Date: 25-Apr-2023  
Our Ref: 2023/90682

**TOWN AND COUNTRY PLANNING ACT 1990  
TOWN AND COUNTRY PLANNING (GENERAL PERMITTED DEVELOPMENT)  
(ENGLAND) ORDER 2015 (as amended), SCHEDULE 2, PART 3, PART MA  
NOTIFICATION OF PROPOSED CHANGE OF USE CLASS MA – COMMERCIAL,  
BUSINESS AND SERVICE USES TO DWELLINGHOUSES  
APPLICATION NUMBER: 2023/90682  
AT: 21, St John's Road, Huddersfield, HD1 5BW**

**Prior approval of a proposed change of use of a building from commercial, business and service uses to dwellinghouses**

BASEMENT PLAN AS EXISTING - NO CHANGE

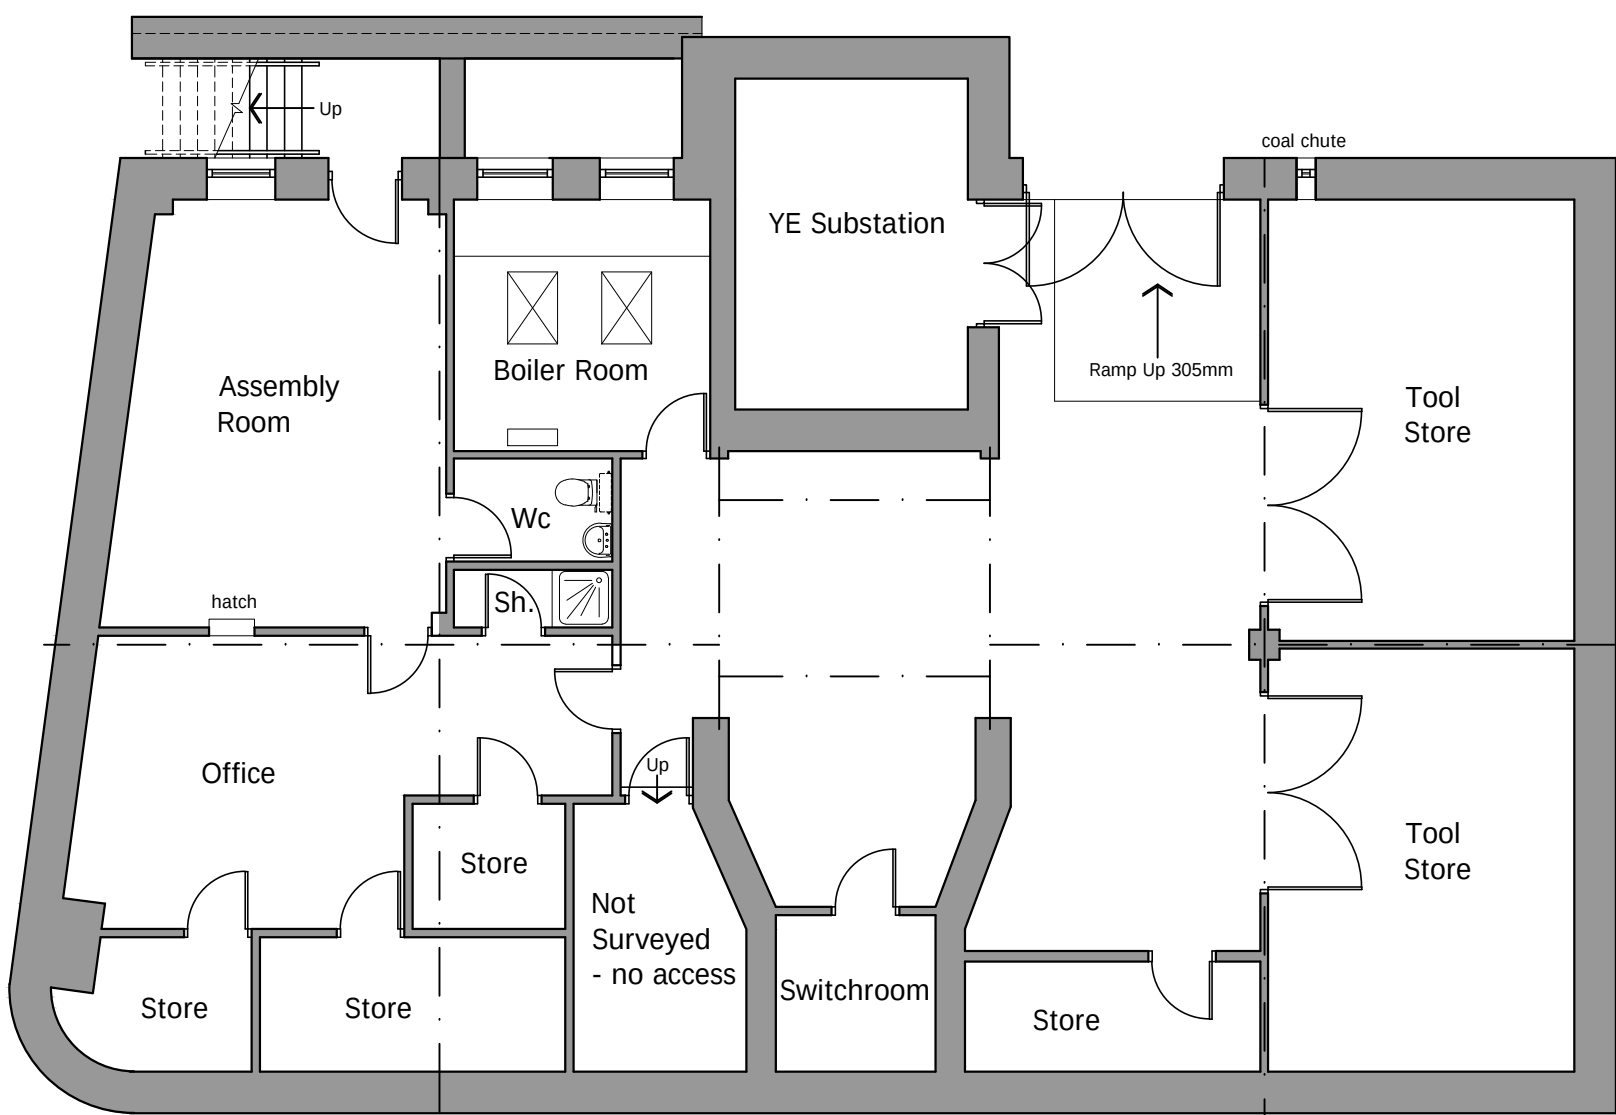
The proposal would fail to comply with requirements as set out by the Town and Country Planning (General Permitted Development)(England) Order 2015 (as amended) Article 3(9A) by not meeting the required space standards.

Part 2A of Part 3, paragraph W of the Town and Country Planning (General Permitted Development)(England) Order (as amended) states that the local planning authority must refuse prior approval if adequate natural light is not provided in all the habitable rooms of the dwellinghouse. In this instance it is considered inadequate natural light is provided into communal living spaces within flats 3, 5 and 7.
